**Written Response
to Able Humber Ports Limited's
Further Information
by the
Royal Society for the Protection of Birds**

15 November 2013

**Planning Application for construction of the Able Marine Energy Park on the
South Bank of the River Humber at Immingham, North Lincolnshire**

**Planning Inspectorate Ref: TR030001
Registration Identification Ref: 10015550**

Figure 27. Distribution of *Hediste diversicolor* (autumn survey).

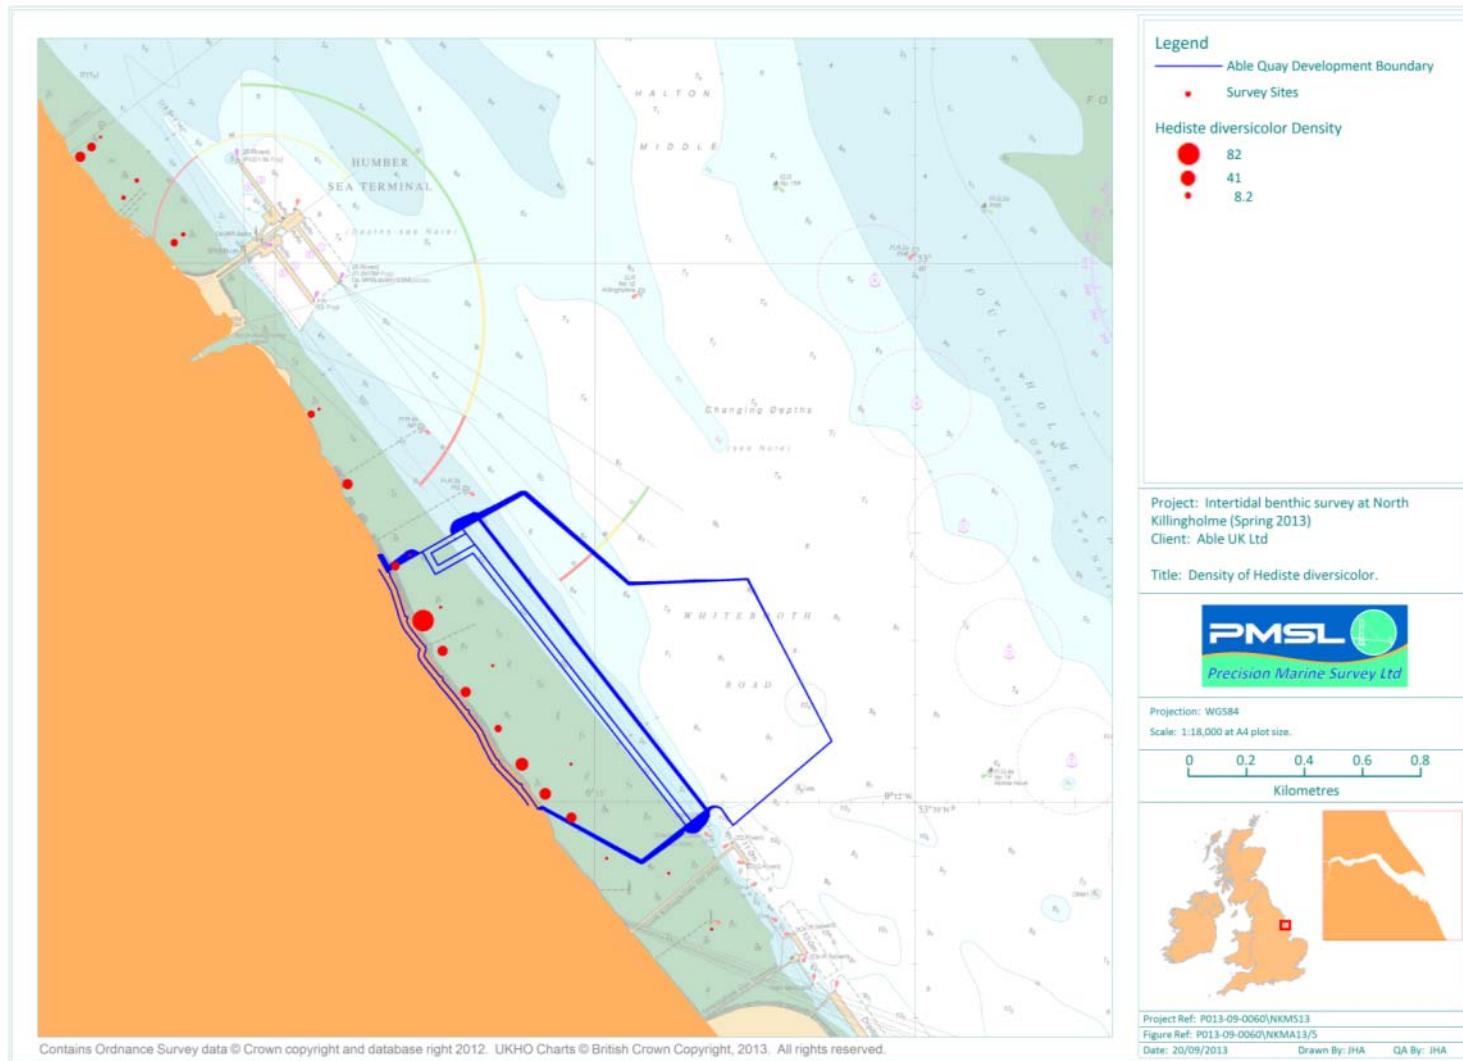
29. Large *Hediste* (the *Hediste* on which BTG feed) burrow to up to 30cm and will rapidly retreat to that depth when disturbed³ (page 250). Surveys entail exactly the sort of disturbance which will trigger this behaviour. This basic point will not be controversial and is well understood by all relevant experts. It is therefore necessary for the surveys to go down to 30cm at least to ensure that the larger *Hediste* are sampled.

30. Inexplicably, this was not done in the most recent surveys. The depth of the samples was only 15cm. Thus, the Recent Surveys still do not properly address the key BTG prey. It appears that a generic invertebrate study has been conducted – a general biotype assessment – but that is not the issue here and the survey is not fit for purpose.

31. Further, despite the correct approach at page 2 of the CEMMP, the studies do not assess the size of the species in the samples. There is thus no evidence in them of the abundance of relevant size prey for BTG. This is a basic flaw in the surveys which means they are simply not relevant to the key question here – namely whether for some reason NKM provides an exceptional food resource for BTG which the fact of their presence in vast numbers strongly suggests and whether an RTE at CCS can replicate that.
